Application by National Highways for A46 Newark Bypass

The Examining Authority's written questions and requests for information (ExQ1)

Issued on 15 October 2024

- NOTES**
- THIS DRAWING IS TO BE READ IN CONJUNCTION WITH THE DRAFT DEVELOPMENT CONSENT ORDER AND ACCOMPANYING APPLICATION DOCUMENTATION. (TR010065/APP/3.1).

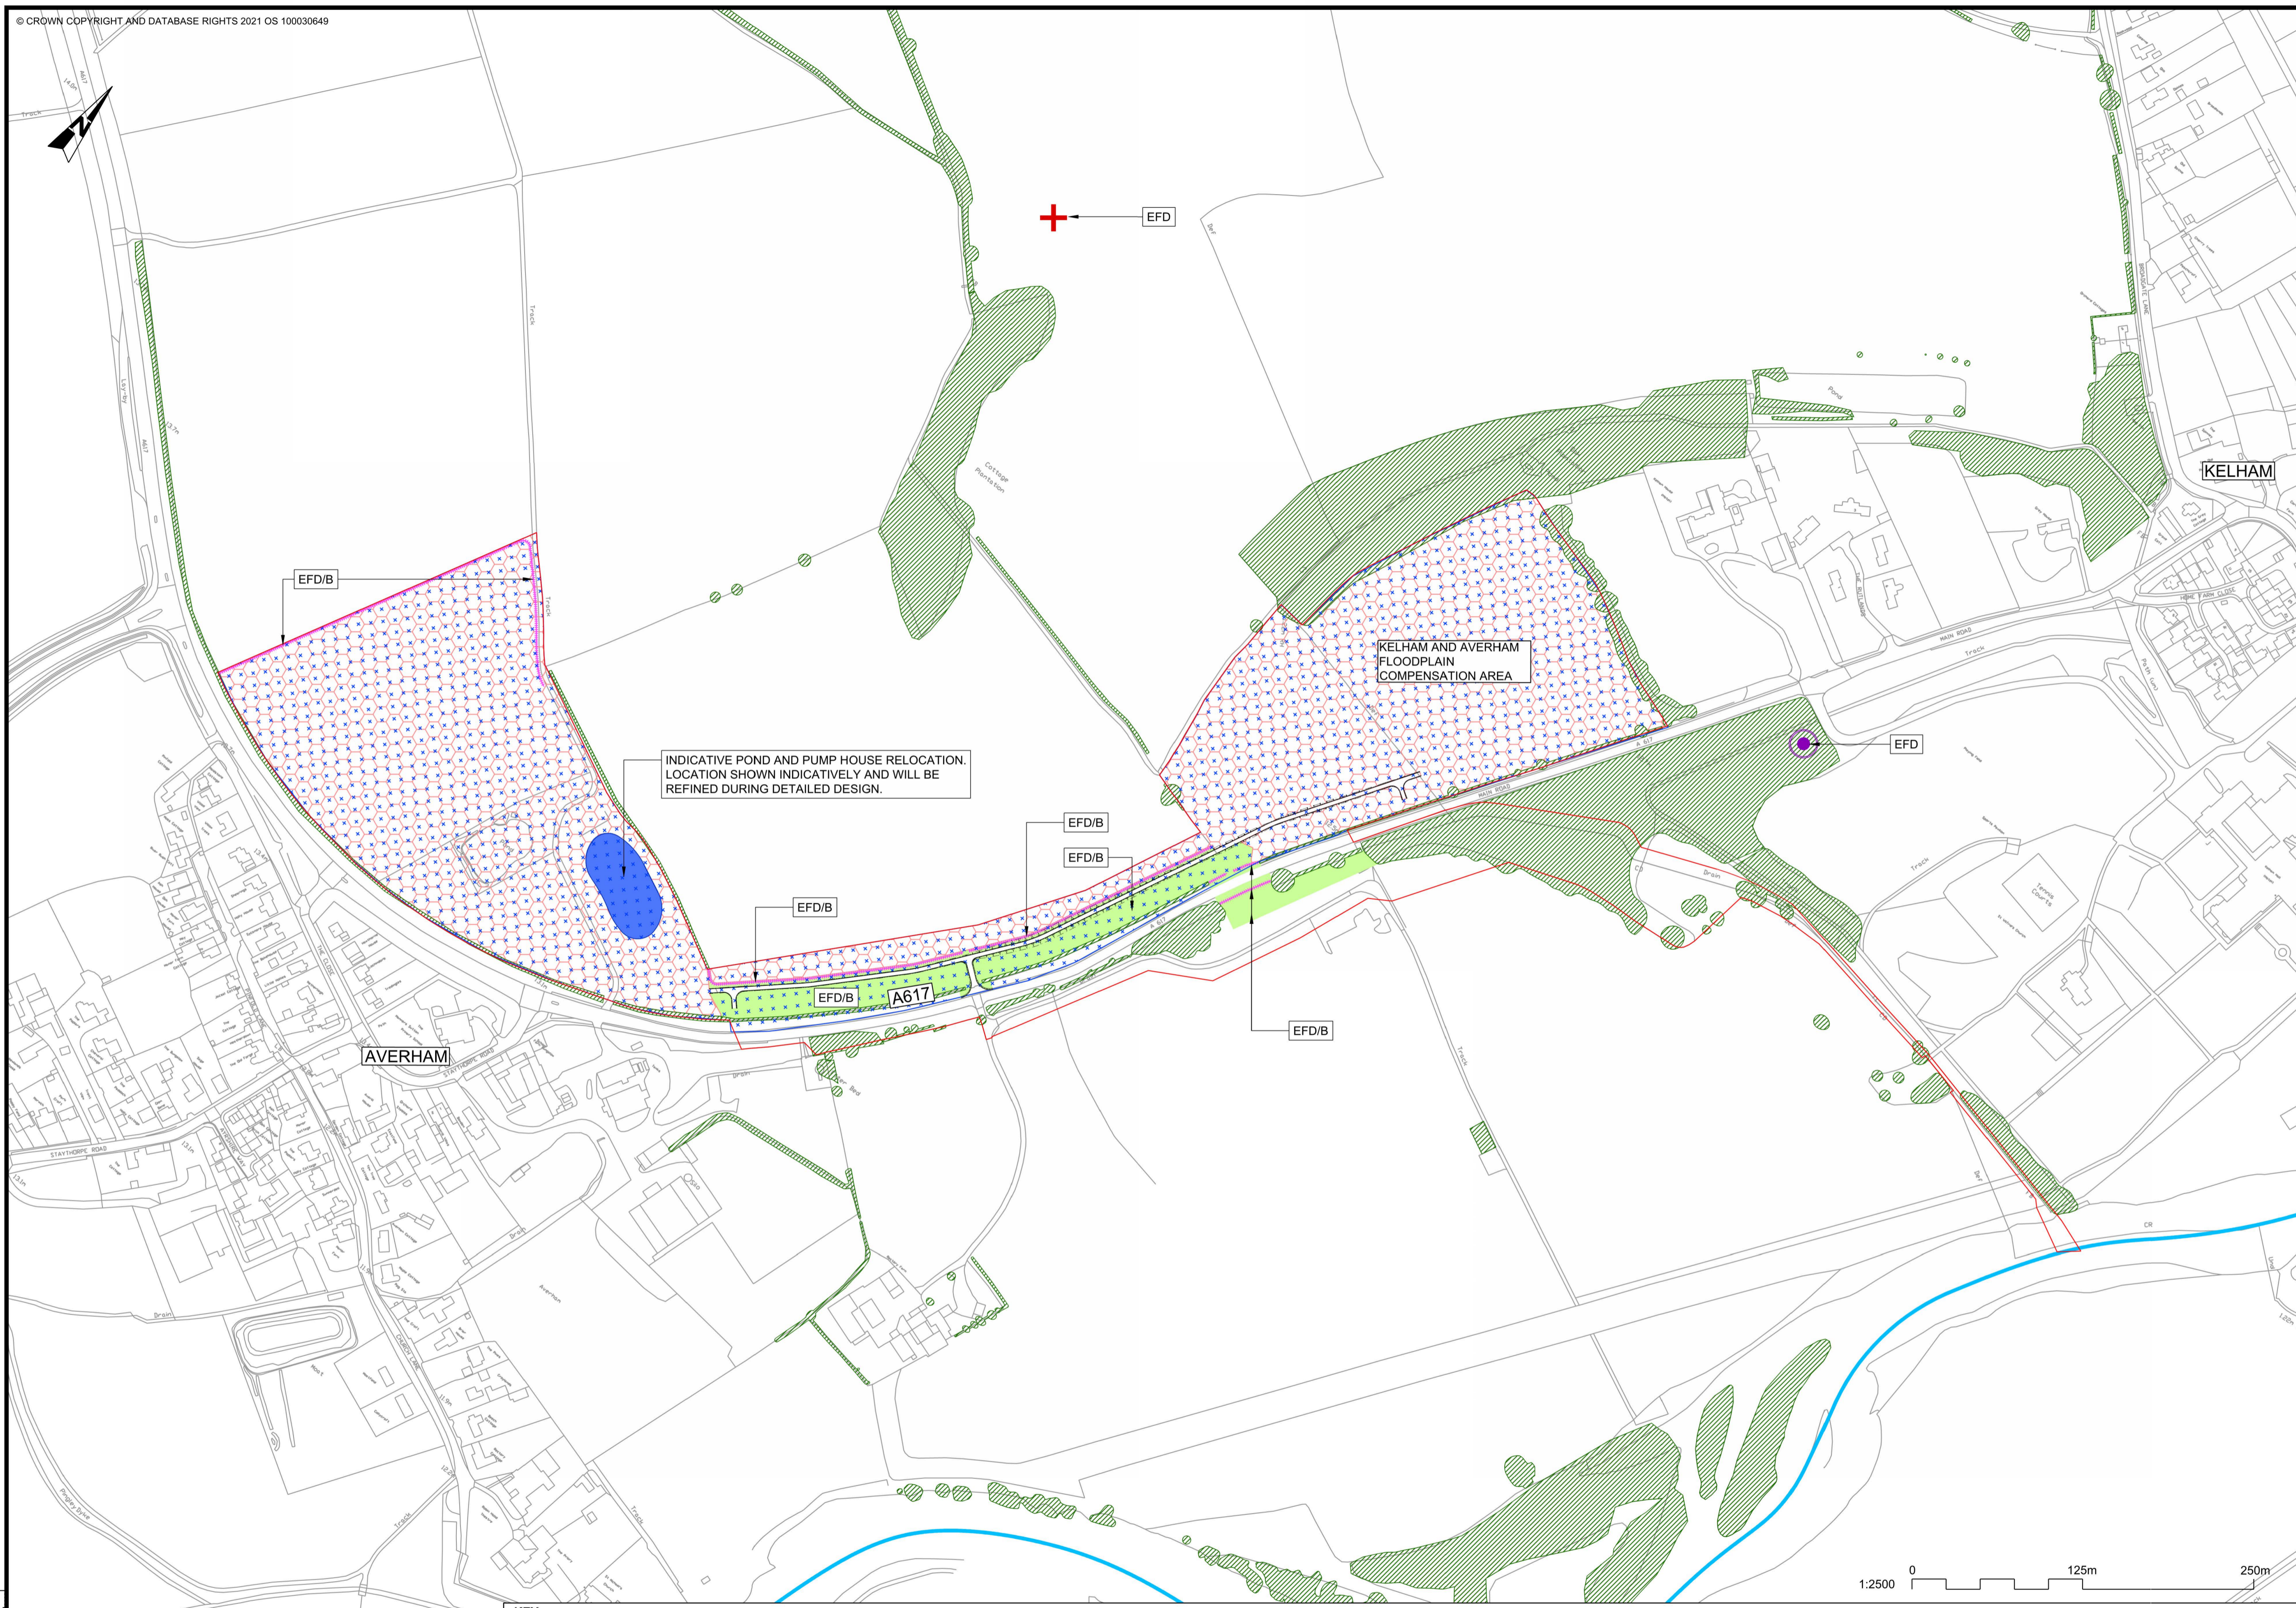
ExQ1	Question to:	Question:
		Figure 2.3 Environmental Masterplan [AS-026] shows compensation measures for barn owl boxes, kestrel boxes and bat boxes and areas of retained vegetation outside the Order limits. How will these be secured in the dDCO and who will be responsible for their maintenance.
Q3.0.4	The Applicant, NSDC	Habitat Severance ES Chapter 8: Biodiversity [APP-052] sets out the impact on habitats through paragraphs 8.11.8 to 8.11.12. This concludes a Slight Adverse effect during construction. With specific reference to the Environmental Masterplan [AS-026] please provide further explanation and justification of this conclusion and when doing so consider how the habitats currently link together creating green corridors and the impact of the Proposed Development to intrude on these networks resulting in habitat severance. Please also provide further detail on what opportunities have been identified to resolve existing issues of severance and those caused by the Proposed Development. Does the Council agree with this conclusion and if not, why not?
